Application No: LU/349/20/HH
Site Address: 32 & 33 Mariners Quay Littlehampton BN17 5DA
Description of works: Extension of rear balconies. This application affects the character & appearance of the Littlehampton (River Road) Conservation Area.

Thank you for your internet representation made on 17th February 2021 which has been recorded as an objection with the comments as follows:

Proposed Elevations

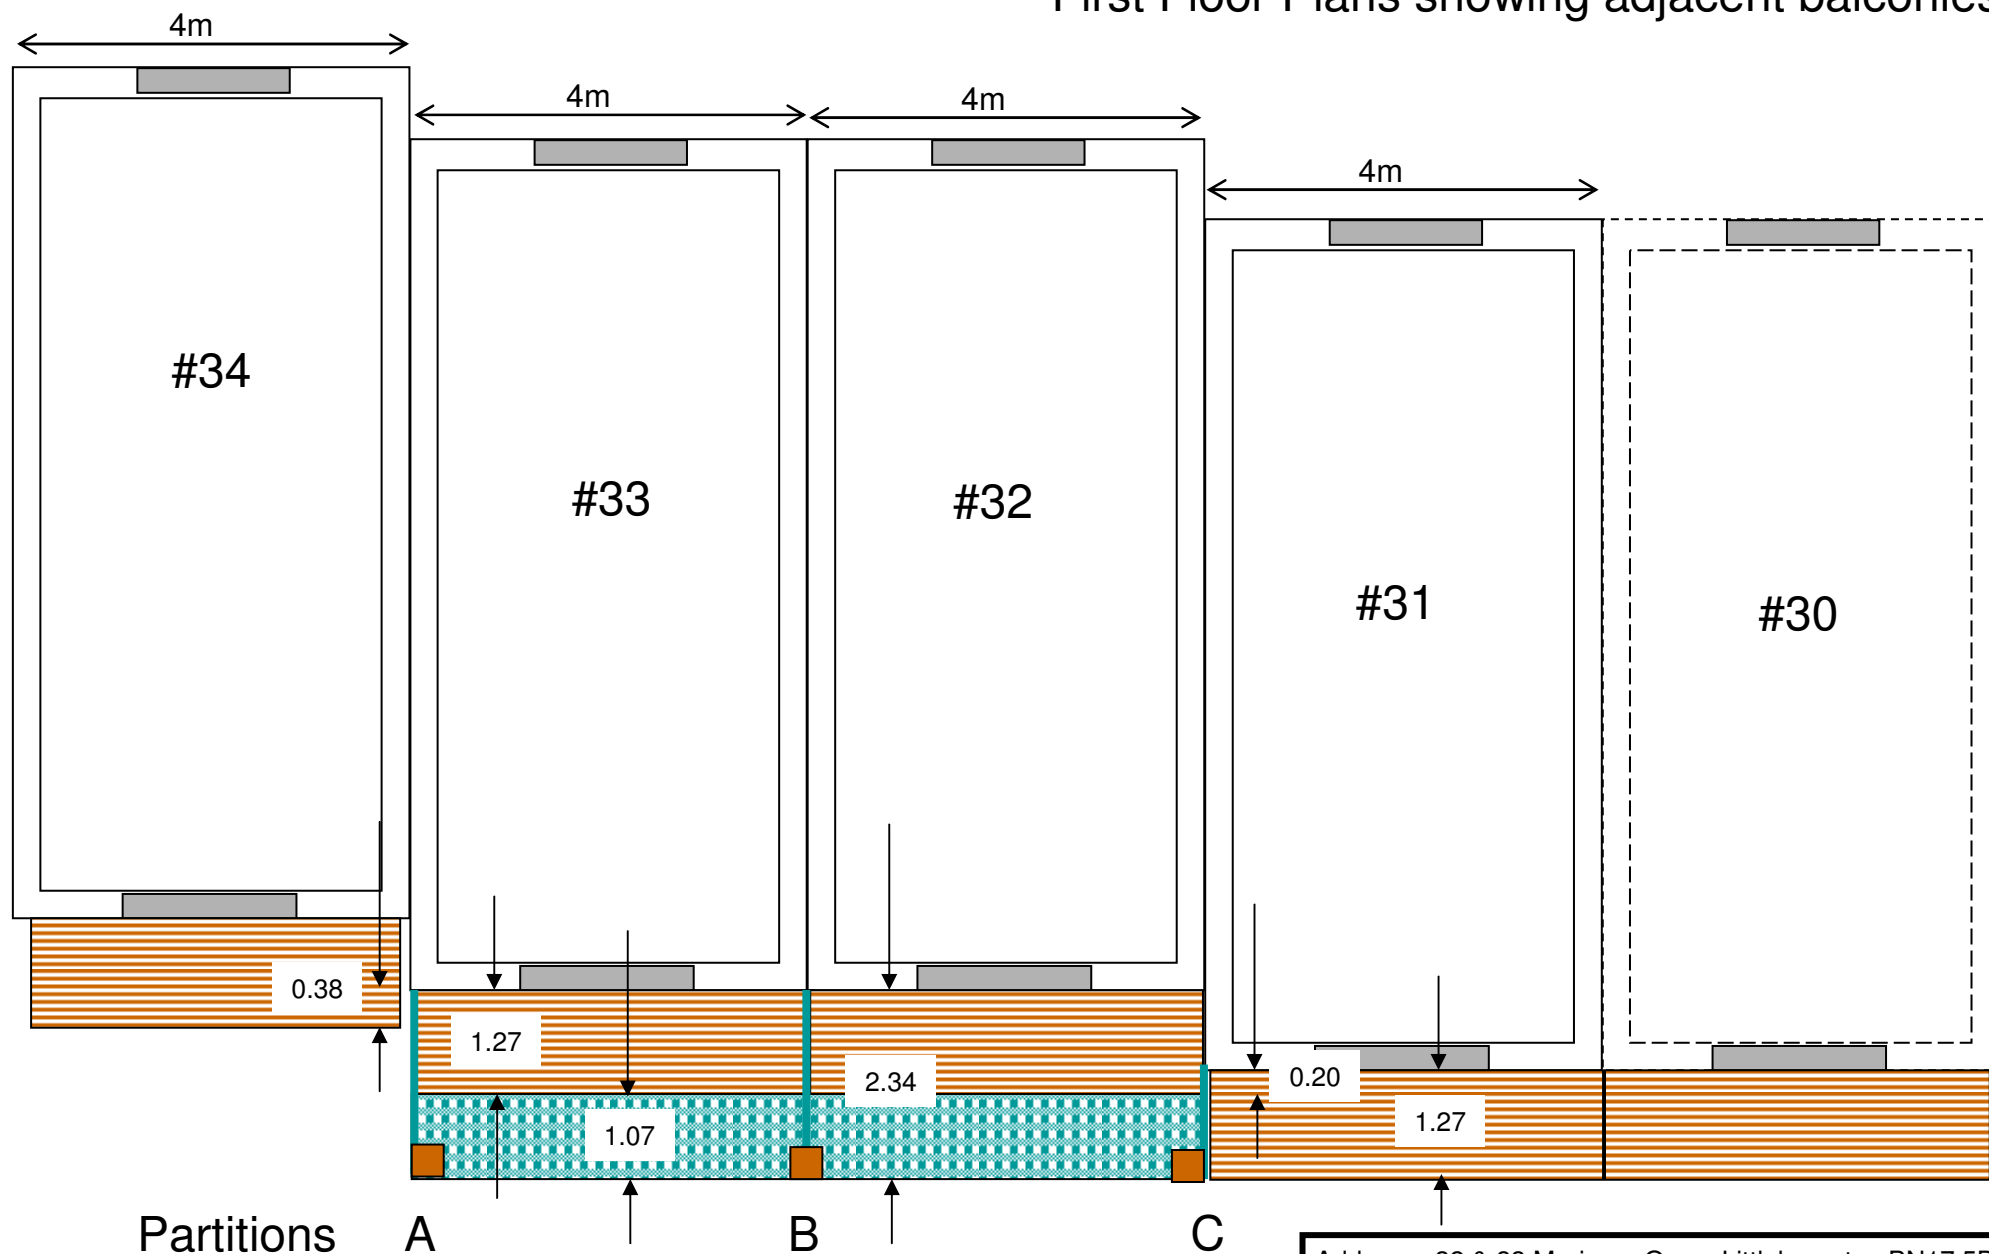
In this proposal the new supporting poles will protrude into the small neat gardens and the extended balconies will take away light and sun from the downstairs rooms of Nos 32 & 33 and neighbouring properties.
